WEST SUSSEX COUNTY COUNCIL CONSULTATION

TO:	Arun District Council FAO: Harry Chalk
FROM:	Highways, WSCC
DATE:	07/10/2025
LOCATION:	Court Wick Park, Courtwick Lane, Littlehampton, BN17 7PD
SUBJECT:	LU/193/25/PL Proposed residential development for 4 houses and associated landscaping. This application may affect the setting of a Listed Building and is in CIL Zone 2 (CIL liable as new dwellings).
DATE OF SITE VISIT:	N/A
RECOMMENDATION:	Advice
S106 CONTRIBUTION TOTAL:	£N/A

Appendix D – Proposed Layout

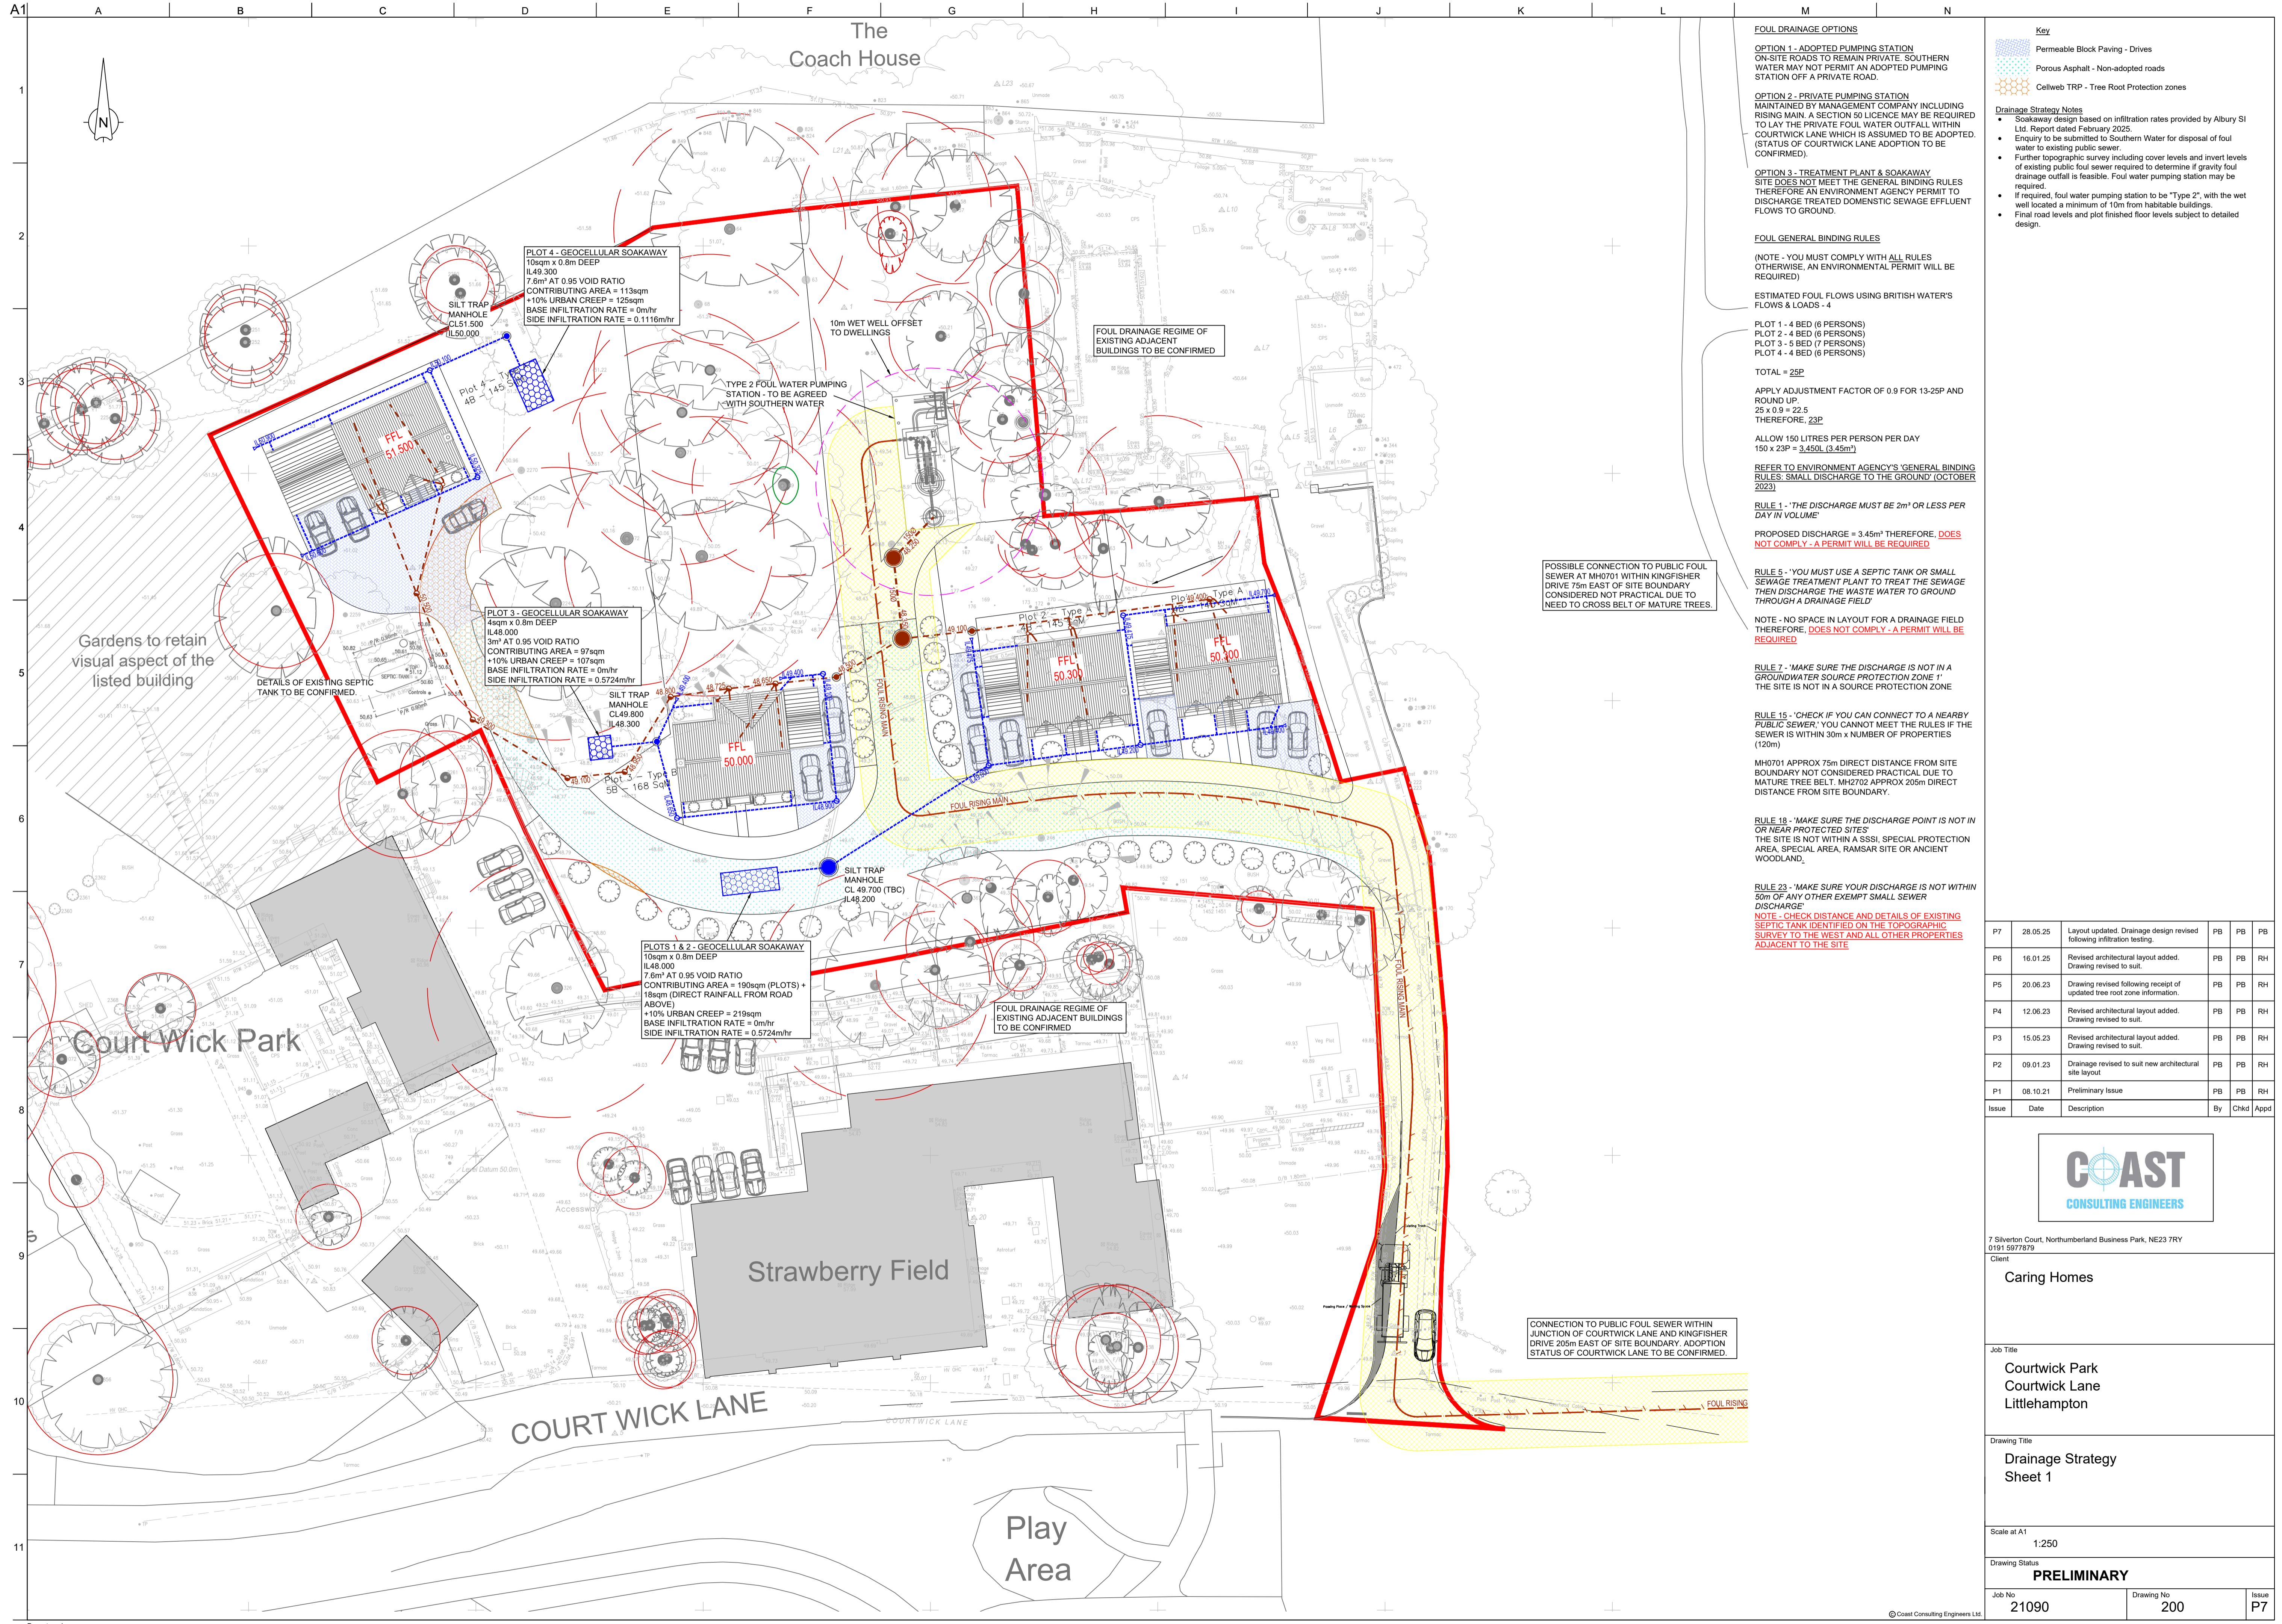
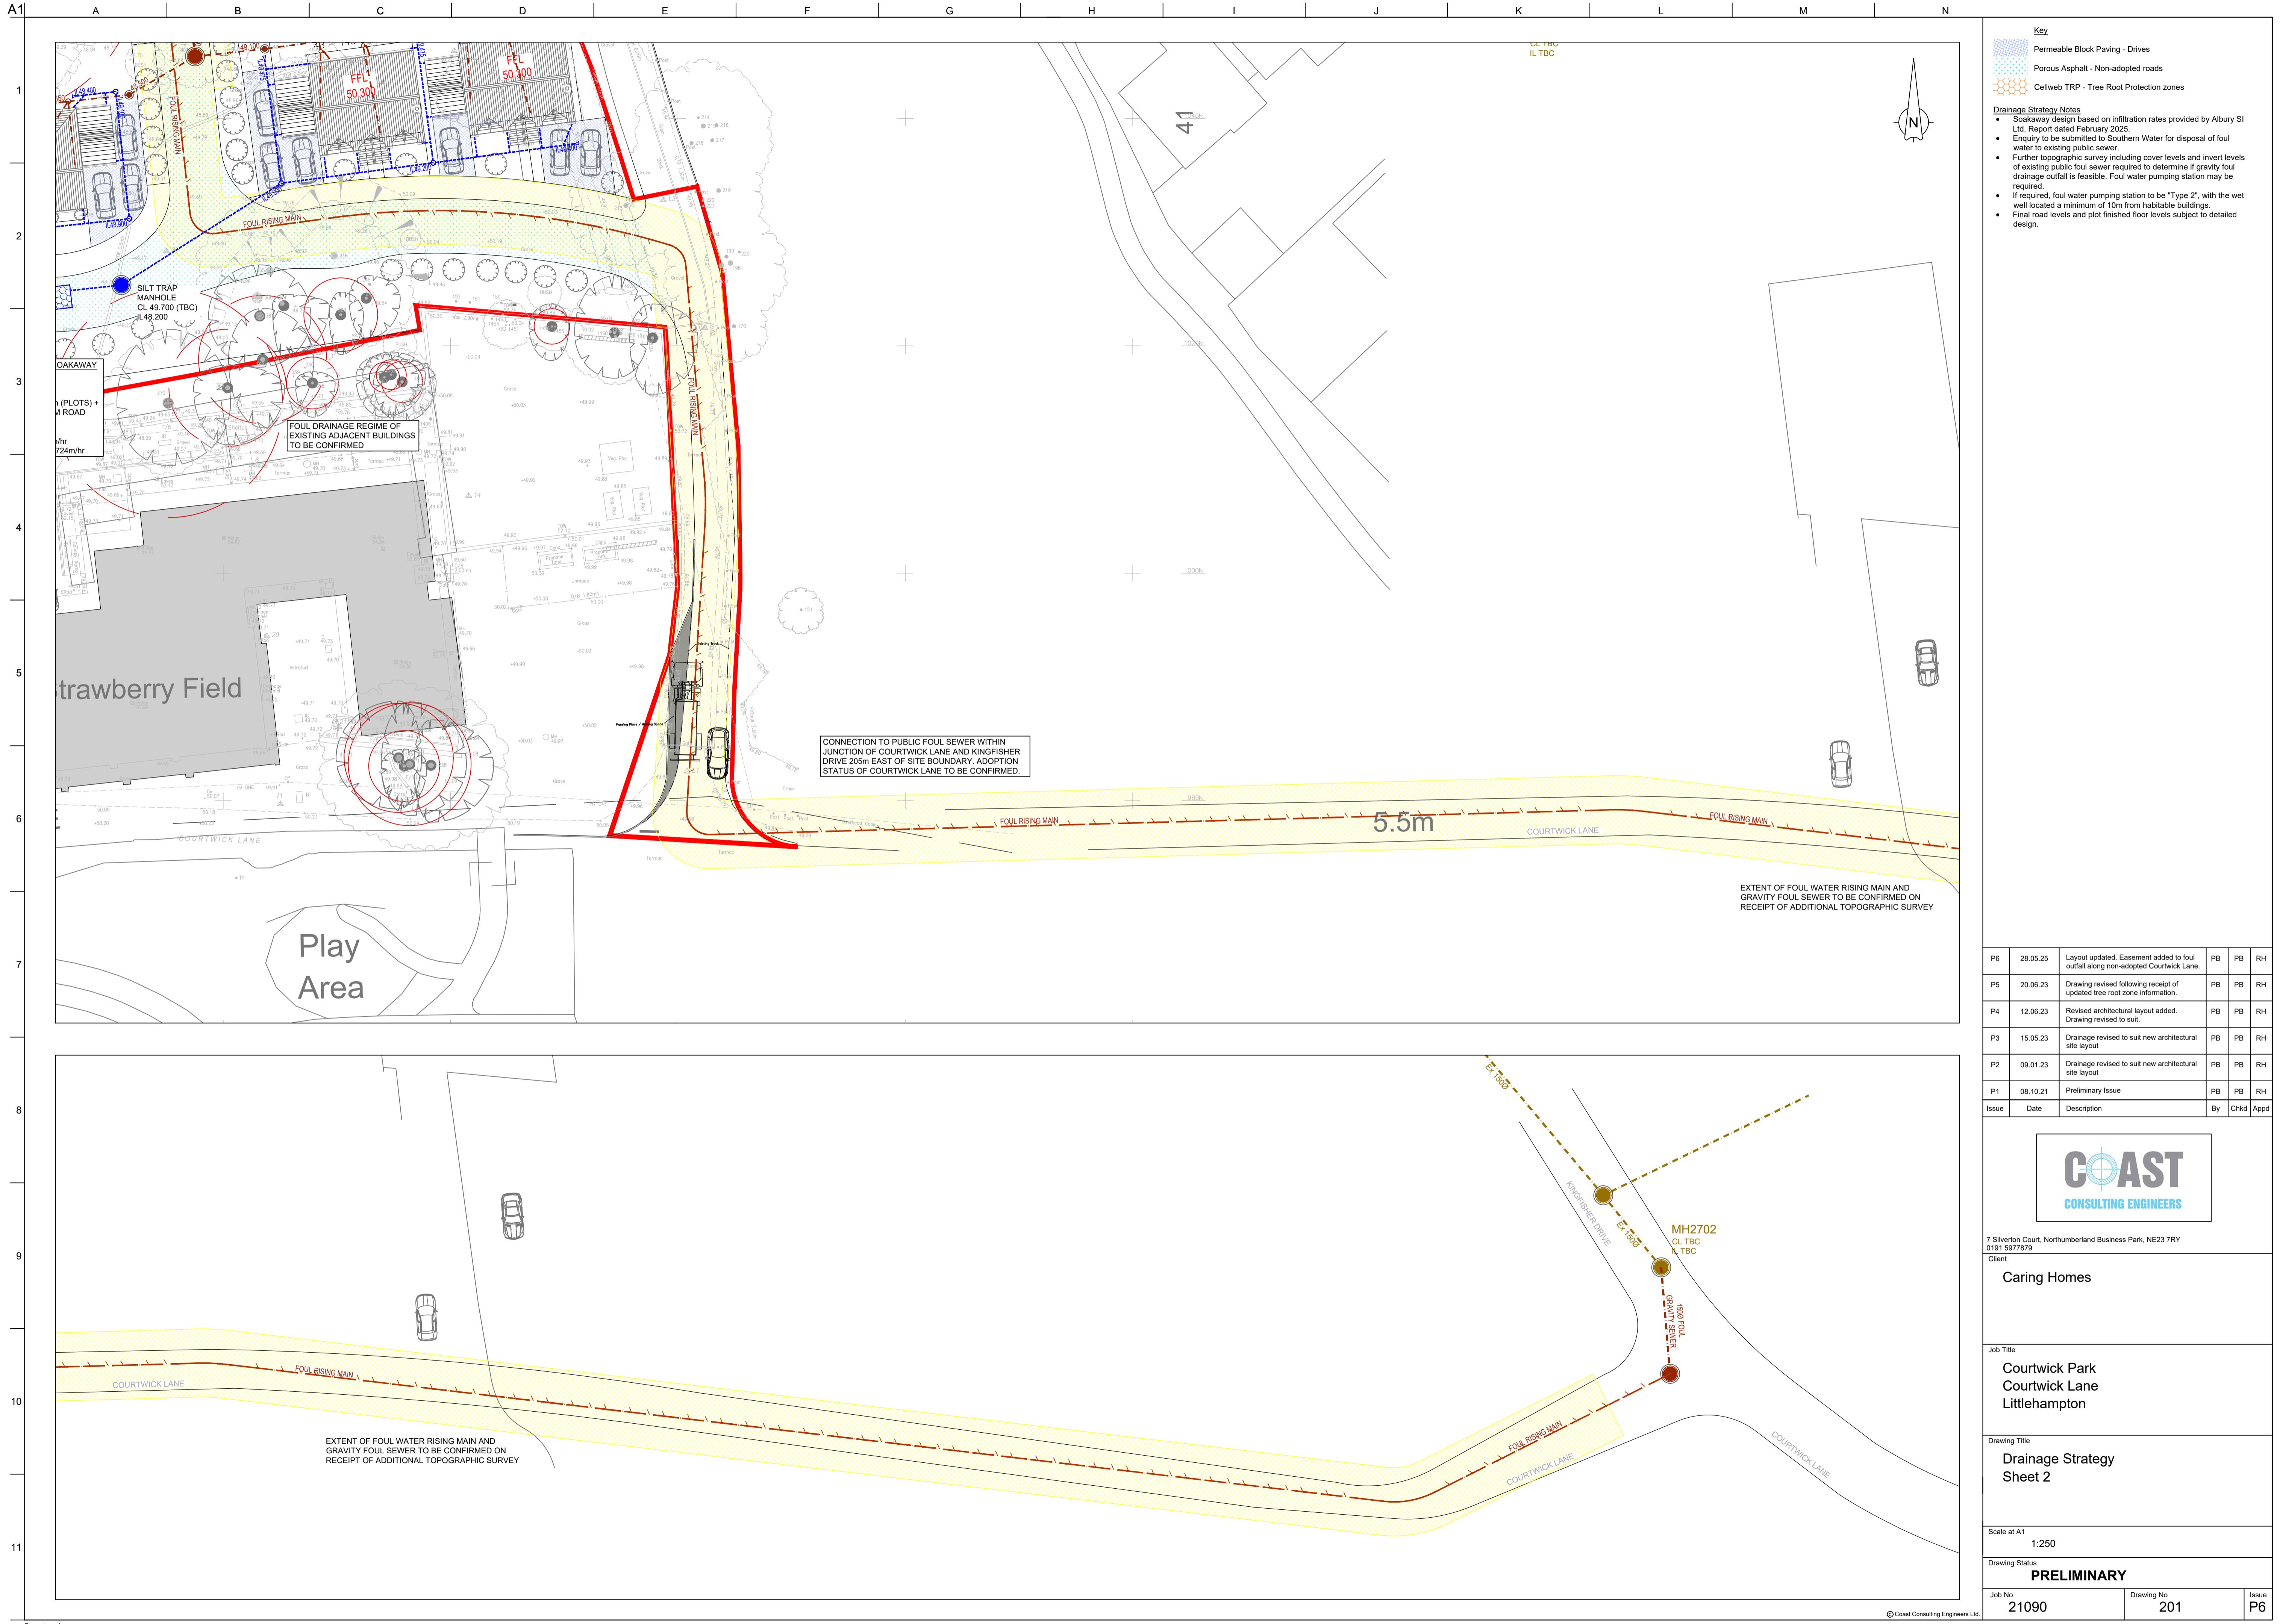
It should be noted that the proposed garages do not meet the minimum internal specifications for garages as outlined in Manual for Streets (MfS). Single-bay garages should have internal dimensions of 3m x 6m, and double-bay garages 6m x 6m. As proposed, the garages cannot be considered for vehicular/cycle parking provision, and the applicant is advised to enlarge the garages to the above specifications.

Notwithstanding the above, the site benefits from a suitable level of car parking provision in accordance with Arun Parking Standards. However, alternate provision for the secure storage of cycles should be provided if the proposed garages are not amended to MfS specifications.

No part of the development shall be first occupied until covered and secure cycle parking spaces have been provided in accordance with plans and details to be submitted to and approved by the Local Planning Authority.
